**SUBJECT: CPSF17-50041775
 BUILDING RESIDENTIAL**

Here are the results of all Inspections located at **40 CYPRESS CHURCH RD:**

FOUNDATION PLAN

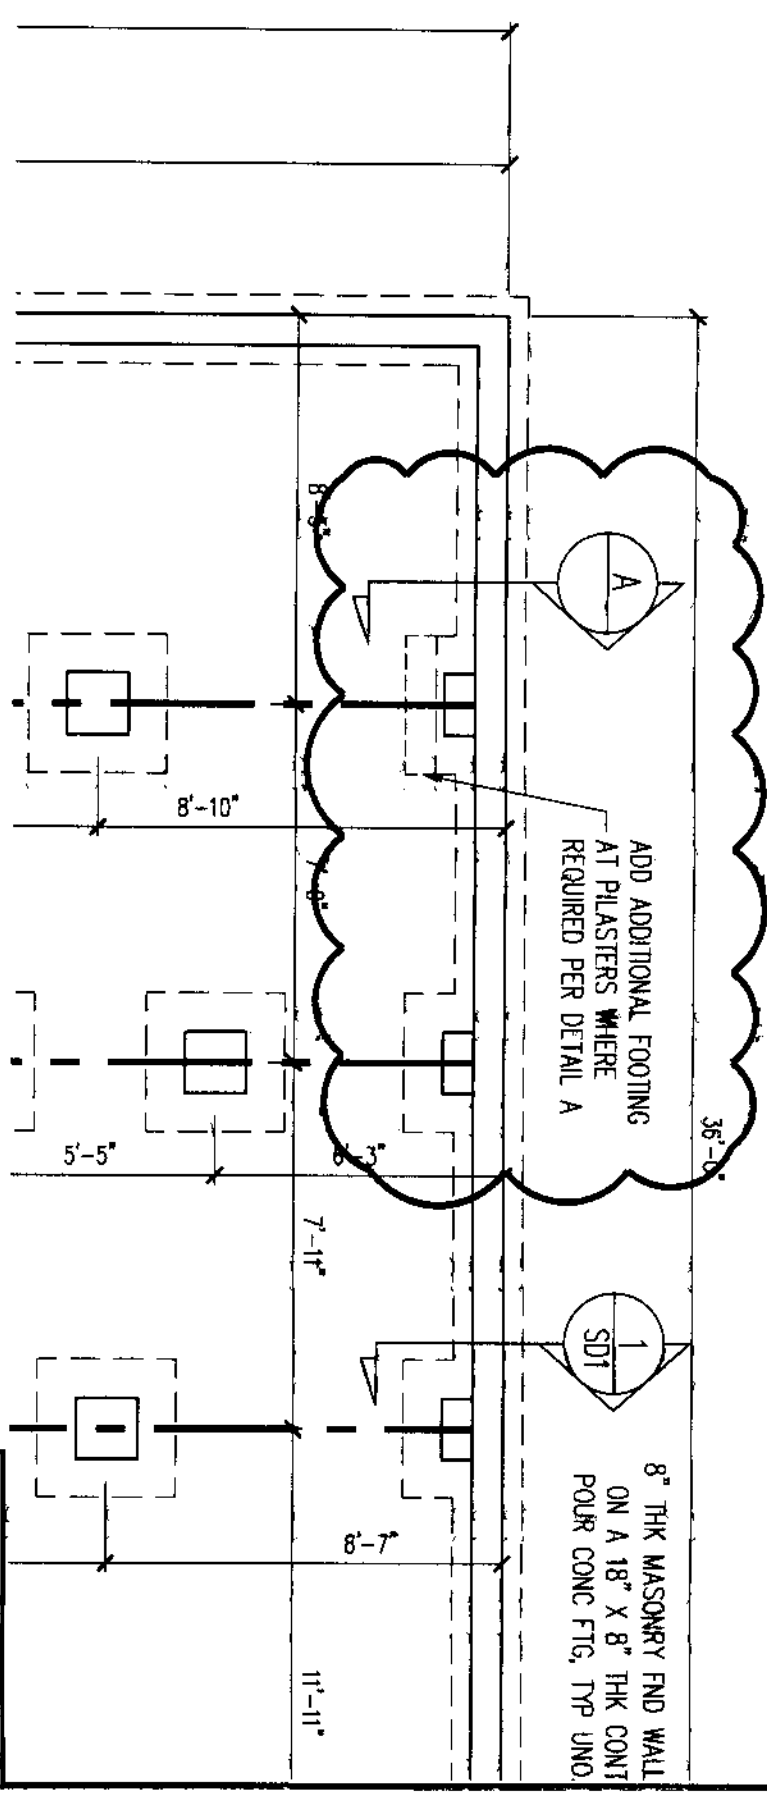
1- GARAGE FOUNDATION NOT INSTALLED. 2-FRONT PORCH PIERS NOT INSTALLED. 3-FRONT FOUNDATION SHOLDER PIERS MISSING PROJECTION, ENGINEERING REPAIR REQUIRED TO CONTINUE.

T/S: 11/21/2017 12:49 PM KSLATTUM ----- Ok to pour footings for pilasters. Foundation not approved because garage and porch foundation not completed.
